Subject: C26-403 and FG/65/26/S73 – Further response and formal representation

1. a follow-up concerning complaint C26-403; and
2. a further formal representation and objection to planning application FG/65/26/S73.

Condition 9 of FG/105/23/PL states:

THE LITTLE TIPPLE, 9 OCEAN PARADE, FERRING
Proposals 01 A
June 2023

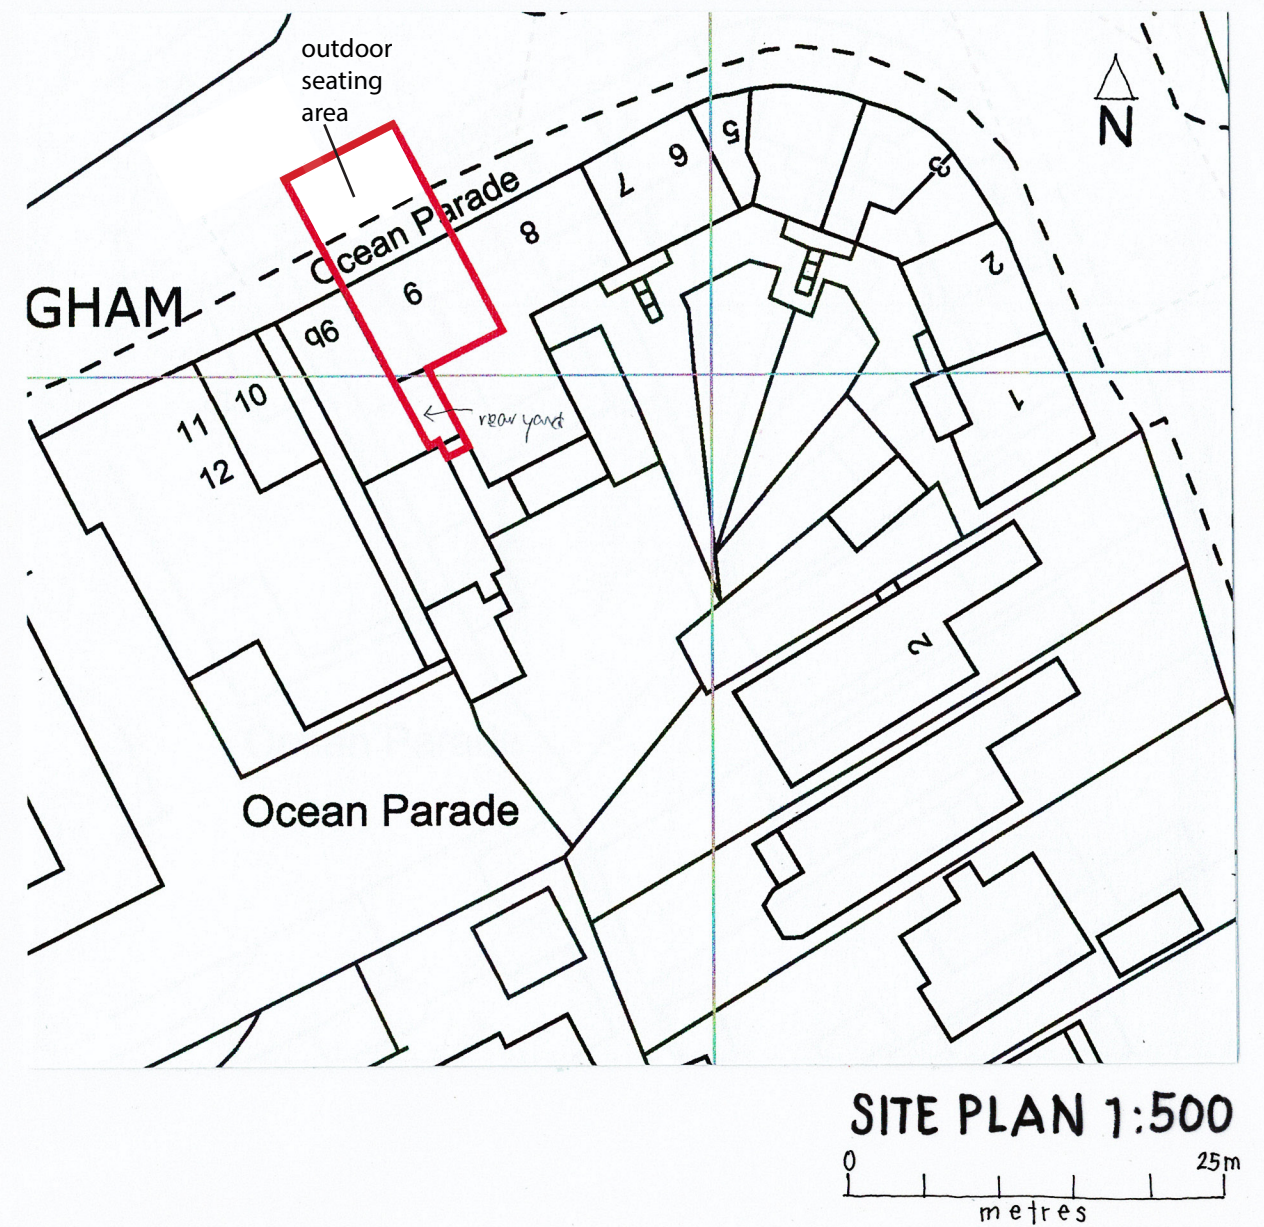
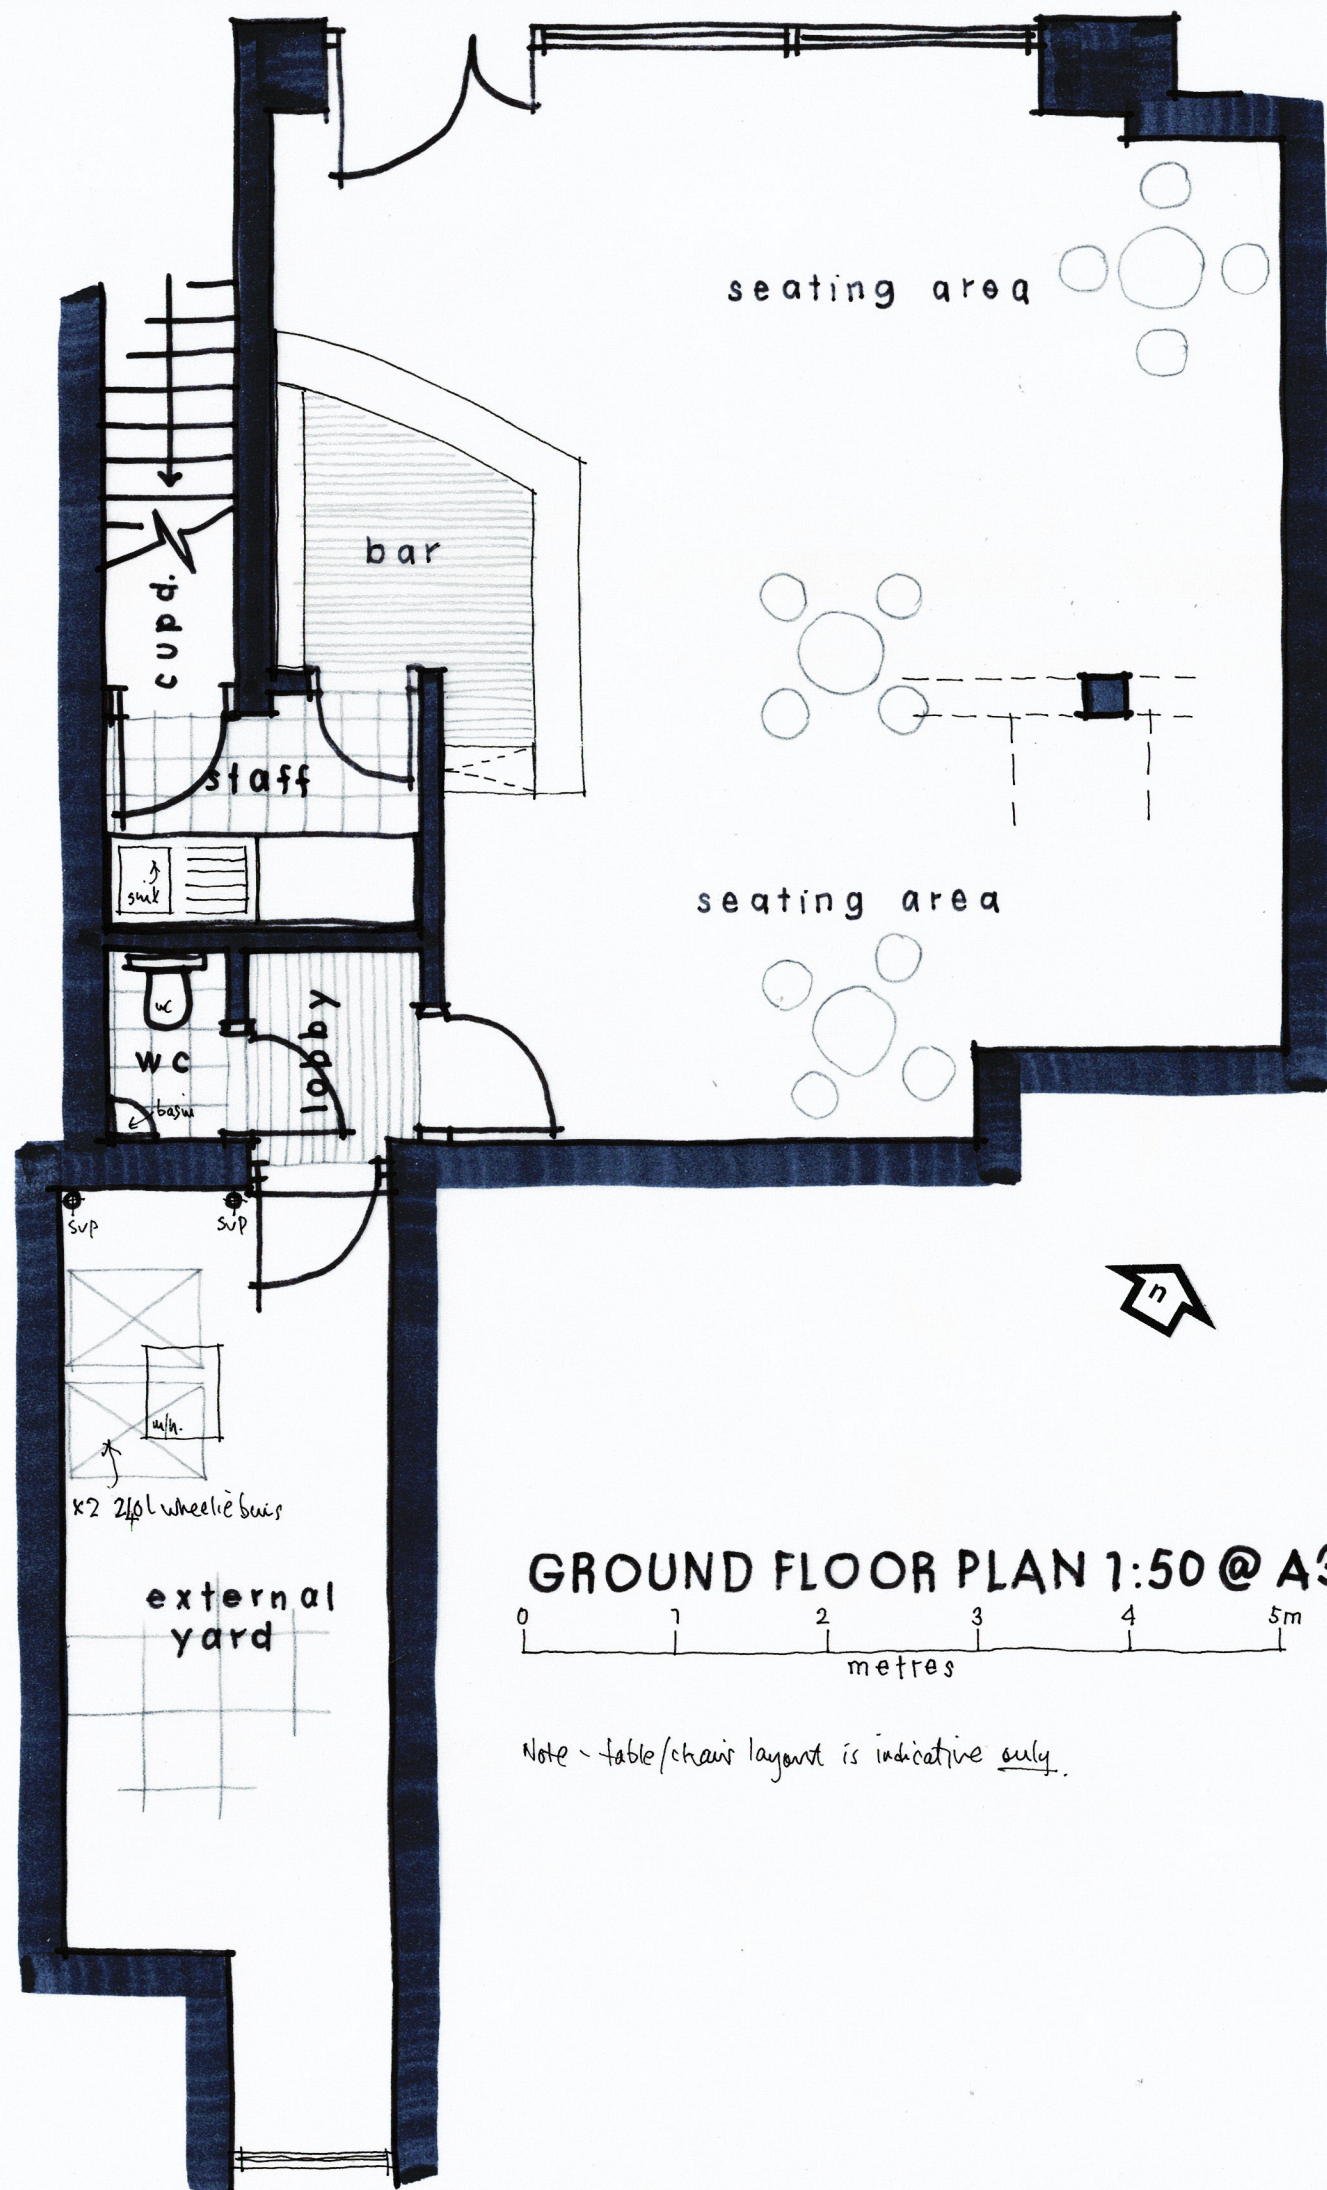
The current application seeks to vary Condition 2 – Plans Condition and does not appear to seek variation or removal of Condition 9.

Section 73 does not provide a general power to alter the description of development or authorise development outside the scope of the original permission. A Section 73 permission is separate, but relevant conditions that are not varied or removed must remain effective. Accordingly, unless Condition 9 is lawfully varied or removed, it continues to prohibit external tables and seating. Approval of a revised plan under Condition 2 should not implicitly override or contradict it.

1. whether the applicant has applied to vary or remove Condition 9;
2. if not, on what legal basis varying Condition 2 alone could authorise seating expressly excluded by Condition 9;
3. whether the application description accurately identifies all development and changes for which

4. whether the submitted plans are consistent with Condition 9; and

5. how the Council would issue a legally and internally consistent decision notice if the revised plan depicts seating while Condition 9 continues to prohibit it.

- that the correct address and extent of the site have been verified;
- that all consultees, including WSCC Highways, considered the correct premises and land;
- that the red-line boundary includes all land on which the seating, tables, chairs, planters, barriers and other structures are proposed;
- that the amended ownership information has been accepted and placed on the public file; and
- whether the proposed seating area lies within the public highway.
